OFFICIAL NOTICE OF DECISION

CITY OF ALBUQUERQUE
PLANNING DEPARTMENT
DEVELOPMENT REVIEW BOARD

Project# 1009030

13DRB-70401 VACATION OF PUBLIC EASEMENT 12DRB-70387 MINOR - PRELIMINARY/ FINAL PLAT APPROVAL

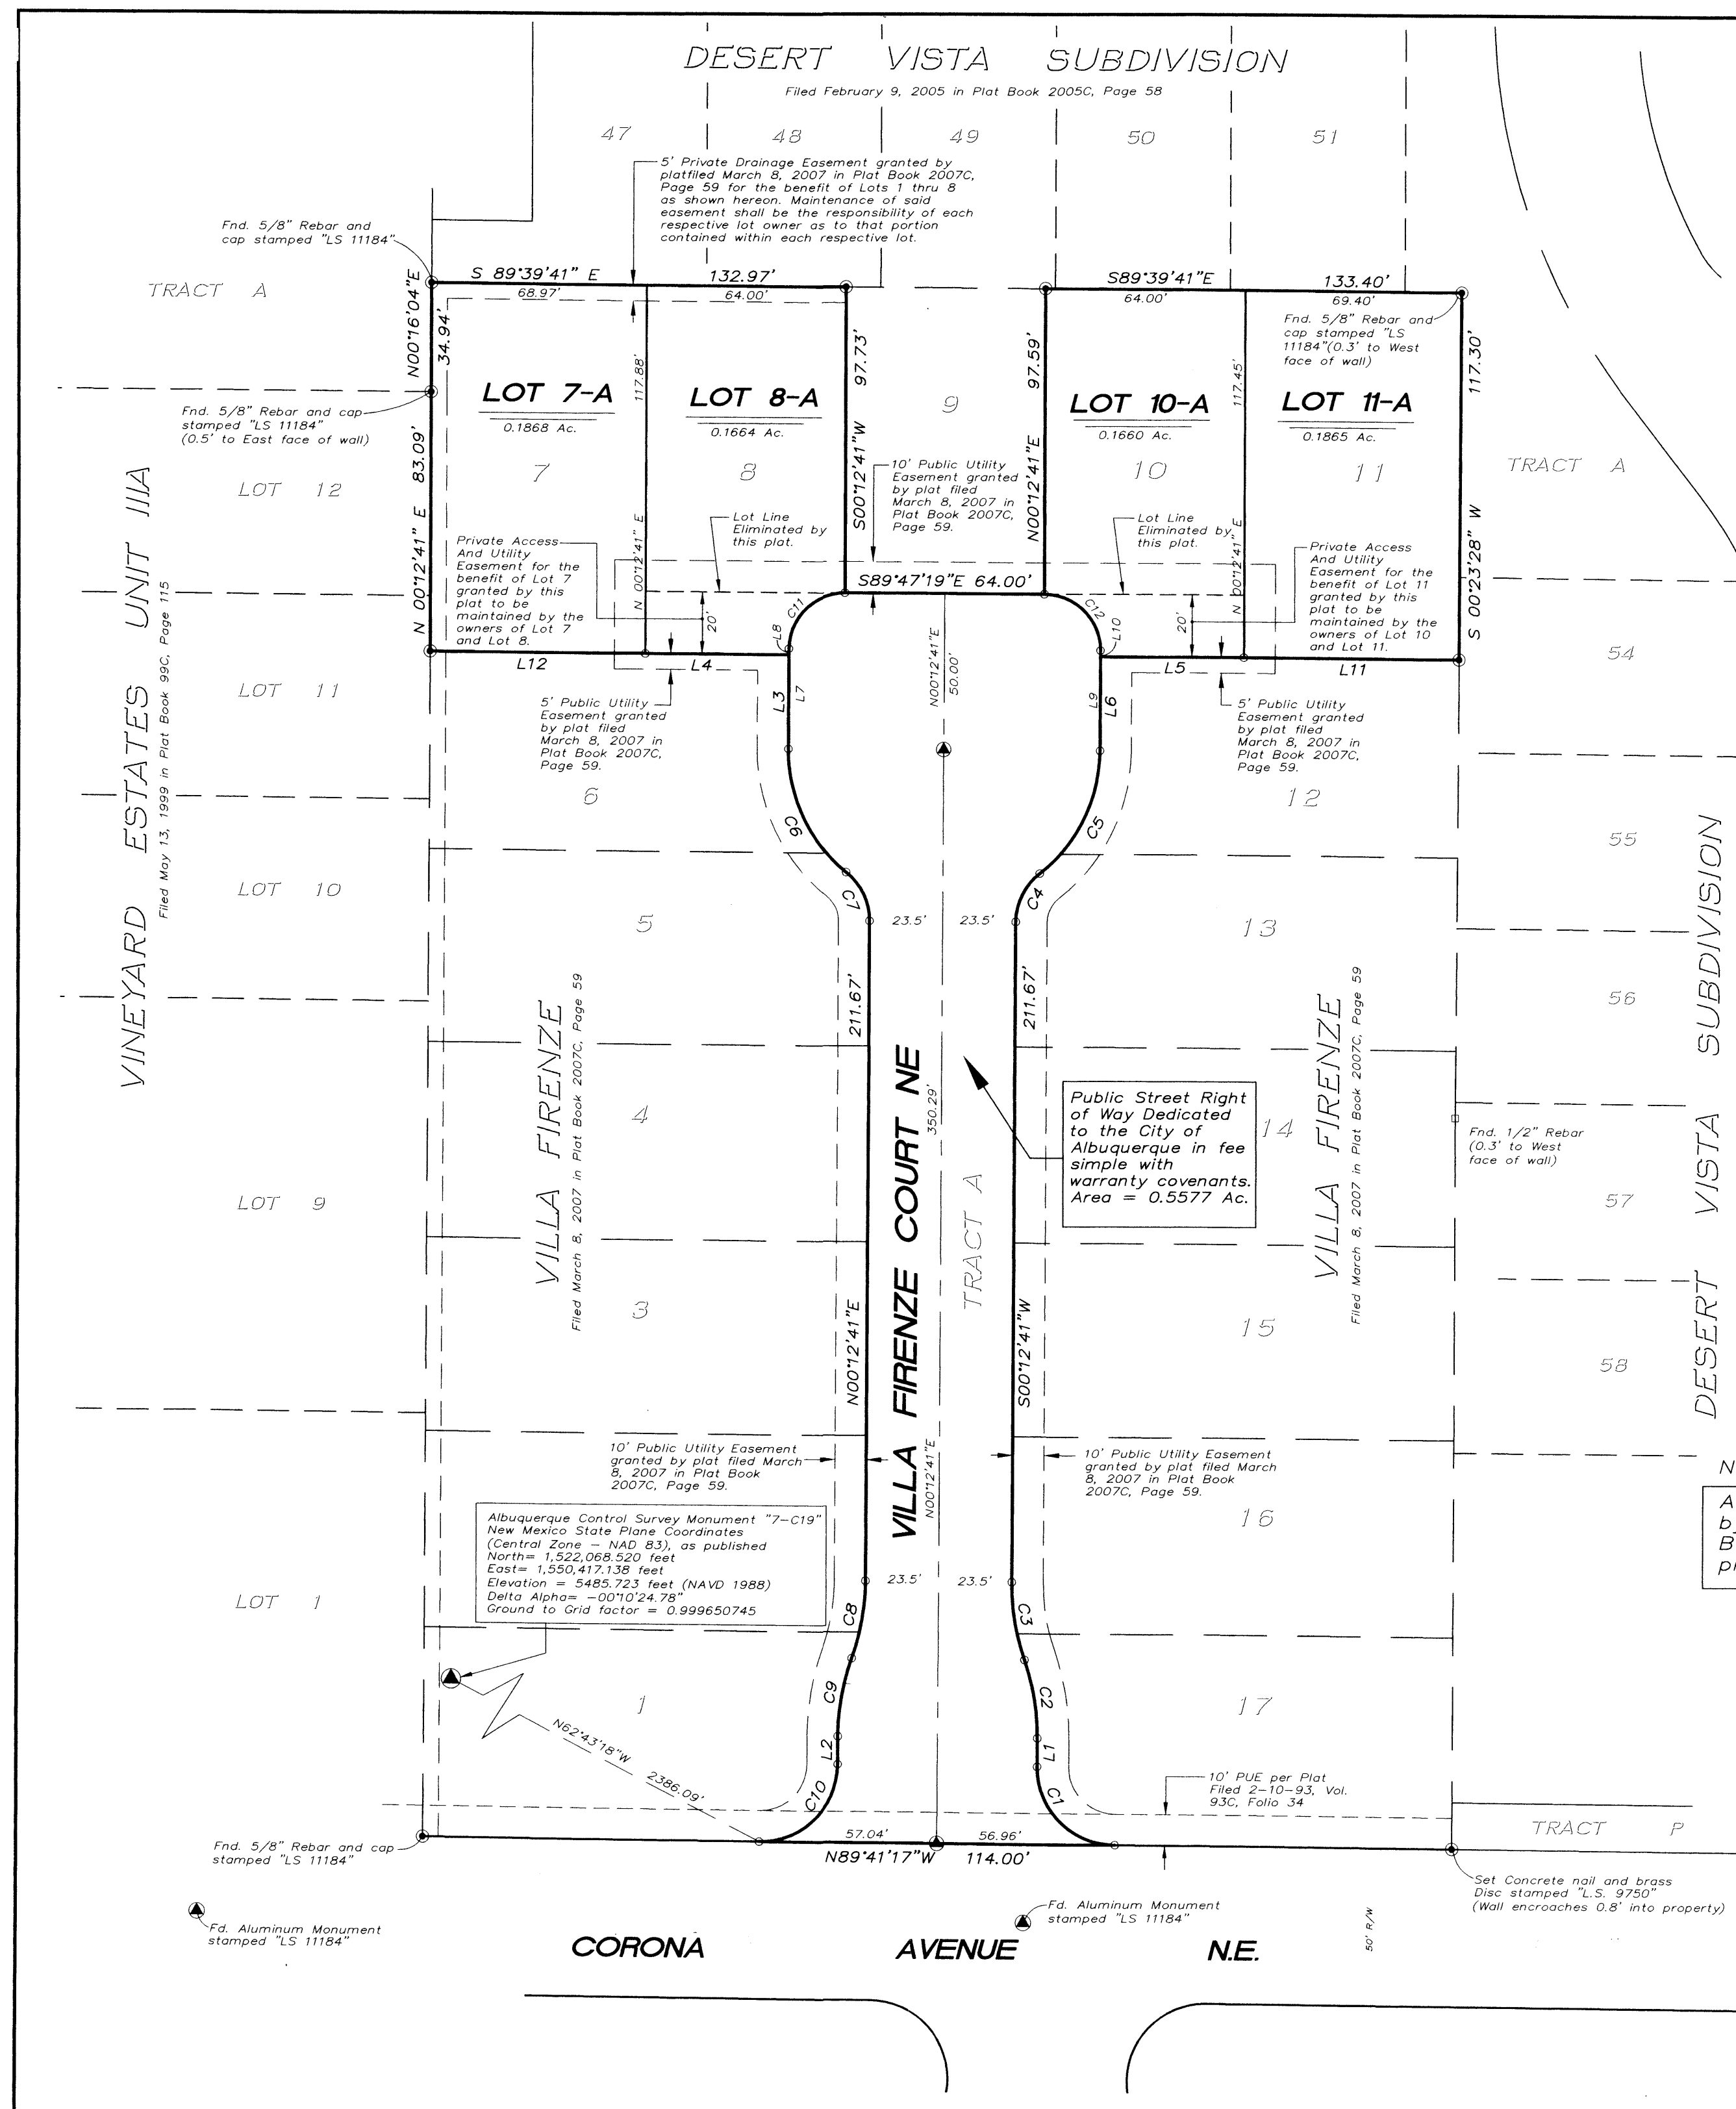
PNM is opposed to this vacation, we currently have facilities in this easement. The Franchised rights do not offer the same protection that we currently have in place with the P.U.E.

In order for the City of Albuquerque to accept a private road into the public roadway system, it must have been built and designed in compliance with current City Standards and Specifications. Please provide the as-built information for this site.

The submittal letter for this project indicates that the Department of Municipal Development has agreed with this proposal and will be requiring a Procedure C-Modified Financial Guarantee. Please provide additional information.

Sorry I missed you call, I am free at 7:30 am today or 8:30 to sign the plat. In the mean time you present this email as an indication that PNM is willing to vacate the easement in the roadway, if we are unable to meet before your DRB hearing.
